**Consultation Response from KC,
Trees**

2023/93237 Brayside, 71, Coach Road, Cowcliffe, Huddersfield, HD2 2NW

Demolition of existing dwelling and garage and erection of detached dwelling with detached garage

Date Responded: 22.01.2024

Drawing Title
Planning Drawing

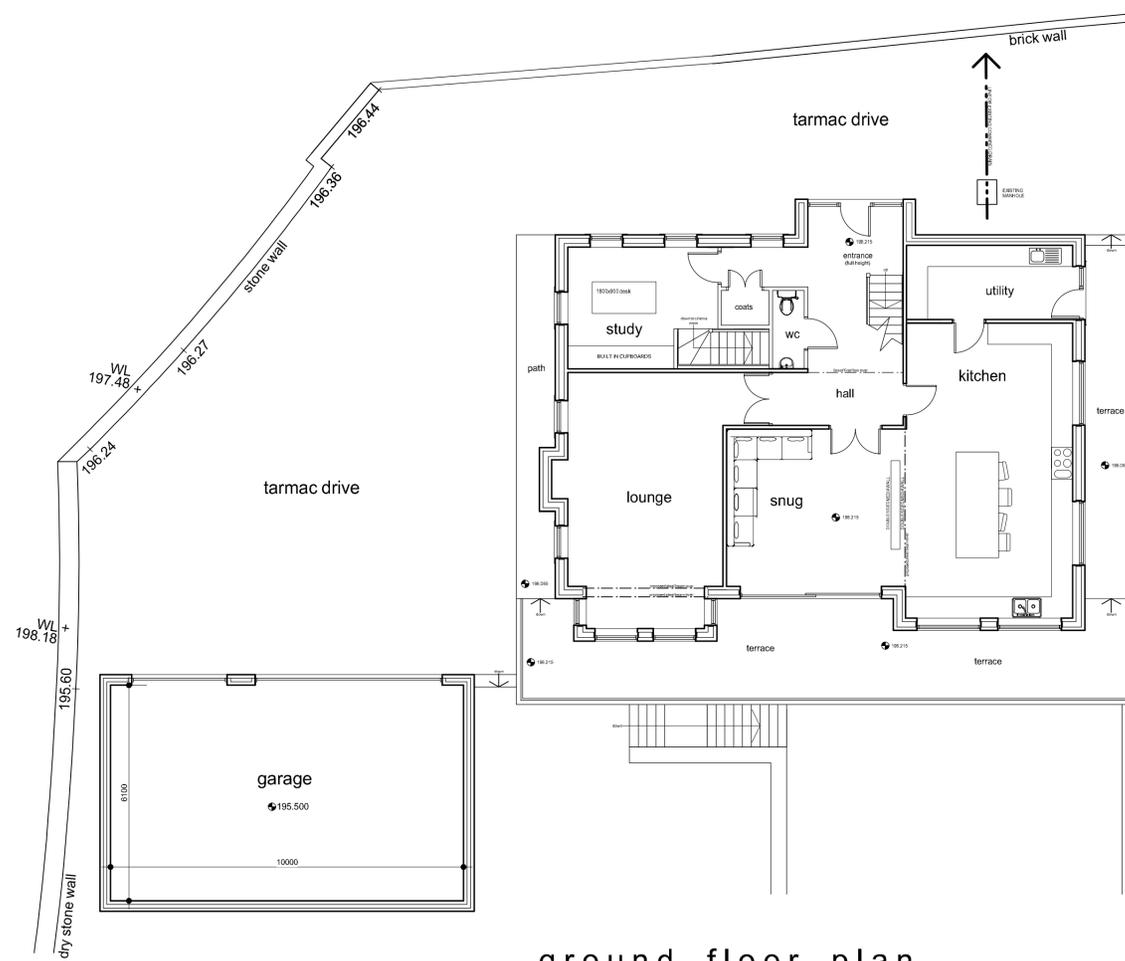
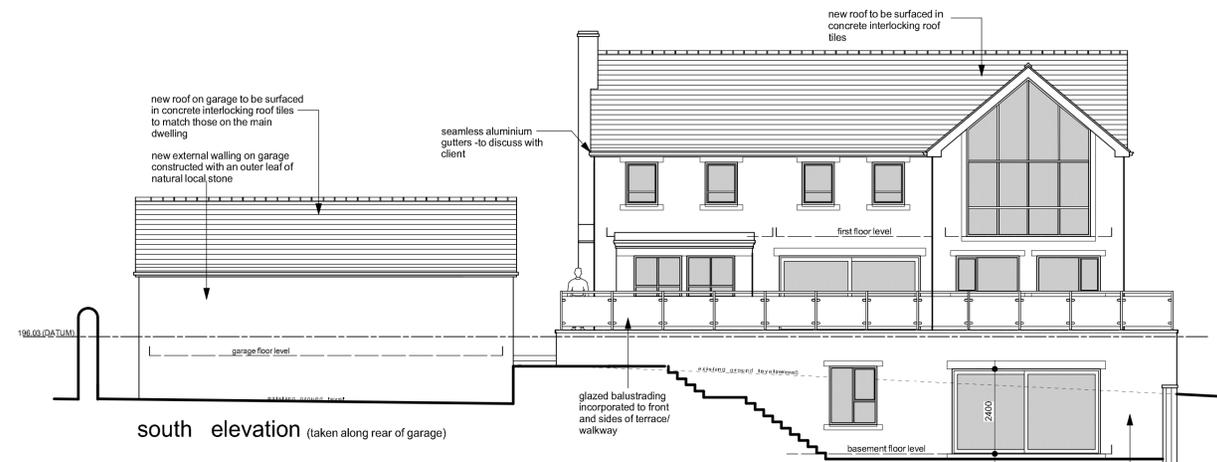
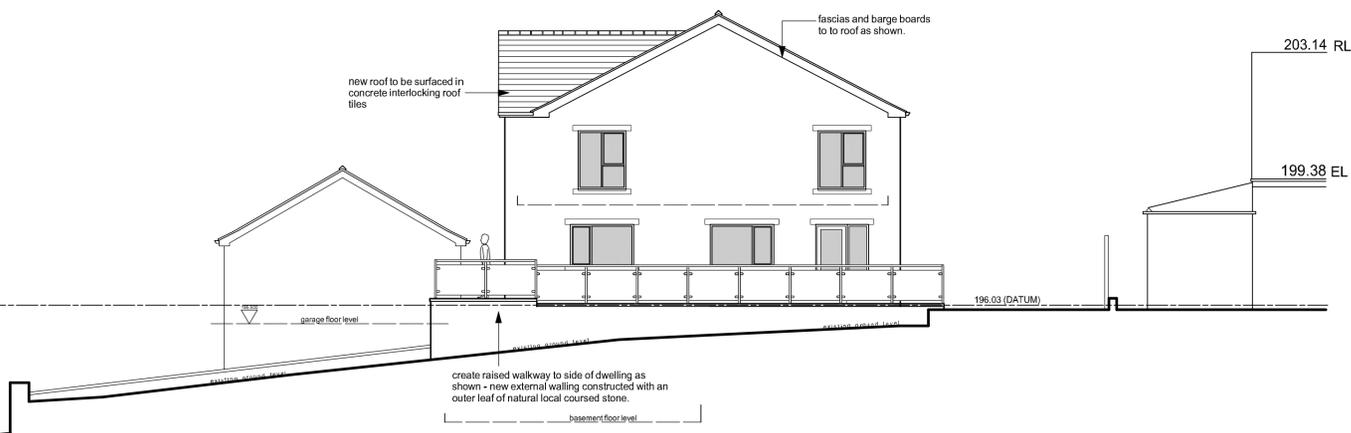
The majority of the proposed work should have no affect on said trees however, the new garage looks to be in very close proximity to the corner of this woodland and may interfere with the root protection area surrounding them. A recommendation would be to relocate the garage to a position further away from the protected trees or alternatively a detailed Arboricultural Impact assessment (AIA) is carried out by a qualified and experienced arboriculturalist. Following this it may be required to obtain an arboricultural method statement to ensure tree protection measures are implemented.

No objections from a trees perspective subject to the following conditions:

Arboricultural impact assessment (AIA) is obtained and should it be required an Arboricultural method statement (AMS) in accordance with BS 5837)
